Site Address: 67 High Street Littlehampton BN17 5EJ

TO:	Arun District Council FAO: Anita Gardner
FROM:	Highways, WSCC
DATE:	8 th June 2018
LOCATION:	67, High Street, Littlehampton, BN17 5EJ
SUBJECT:	LU/76/18/PL 4 No. tables with chairs & awning to front elevation. This application affects the setting of a listed building.
RECOMMENDATION:	☒ Advice ☐ Objection ☒ Modification ☐ No Objection ☐ More Information ☐ Refusal
S106 CONTRIBUTION TOTAL:	£N/A

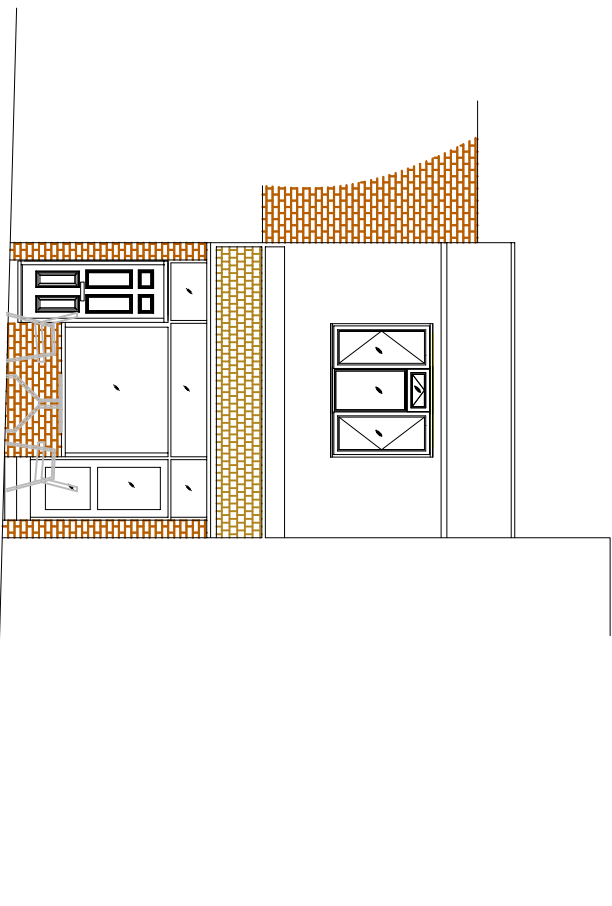
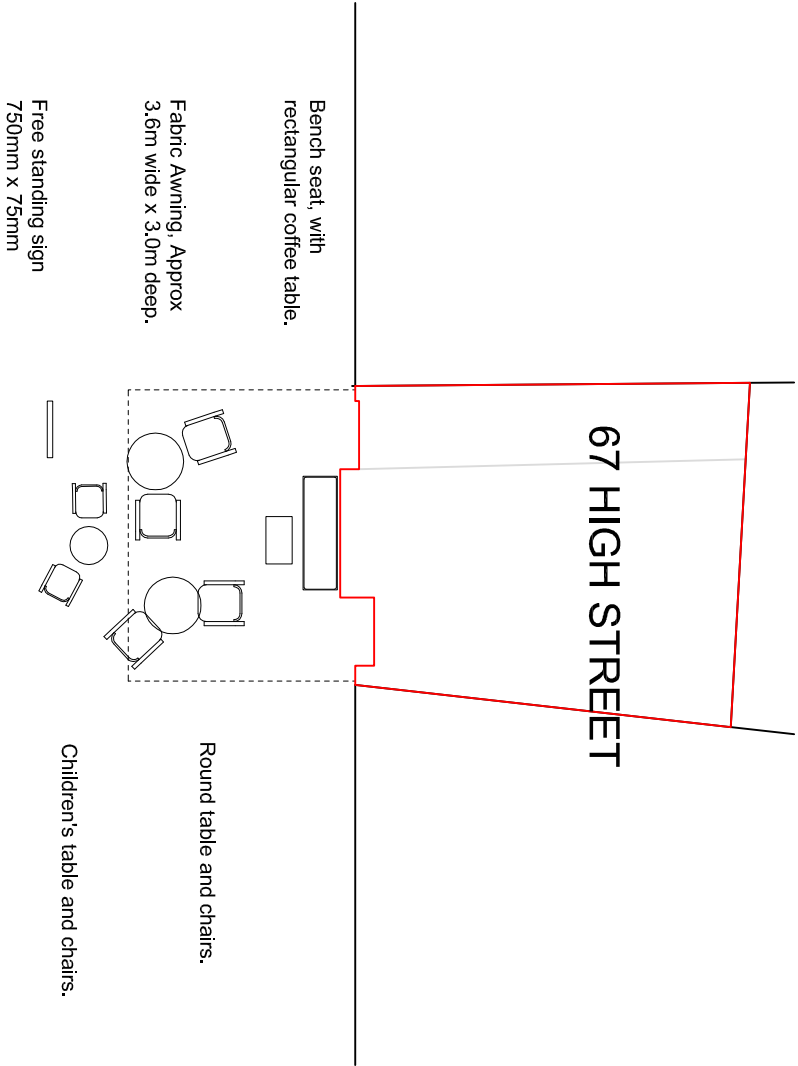
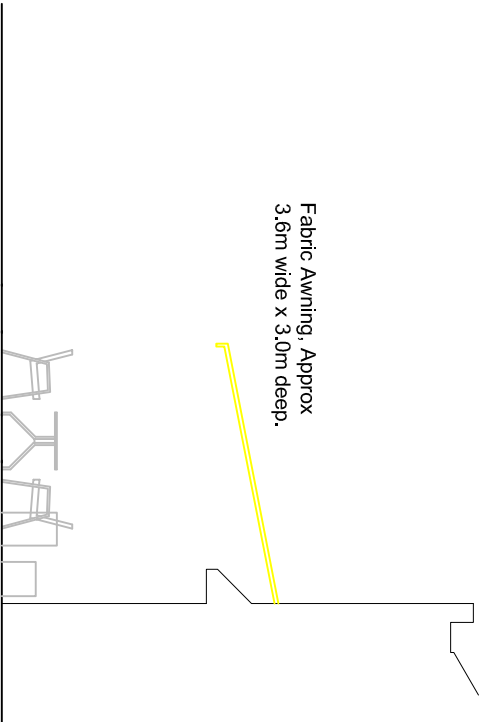
The application is for placement of tables and chairs within the public highway. High Street is pedestrianised and approximately 14 metre wide in this location. The placement of the tables and chairs will occupy approximately 4m width adjacent no. 67. The Local Highway Authority (LHA) considers that sufficient space will remain for pedestrians and wheelchair users along this section of High Street.

The Arun Area Engineer has been consulted regards the granting of a licence for tables and chairs in the highway. I note that a free-standing sign is proposed within the public highway; whilst this does not appear to obstruct the free flow of pedestrians the Area Office generally do not permit private signs within the highway.

The applicant would also be advised to consider providing a removable barrier to keep the tables and chairs enclosed.
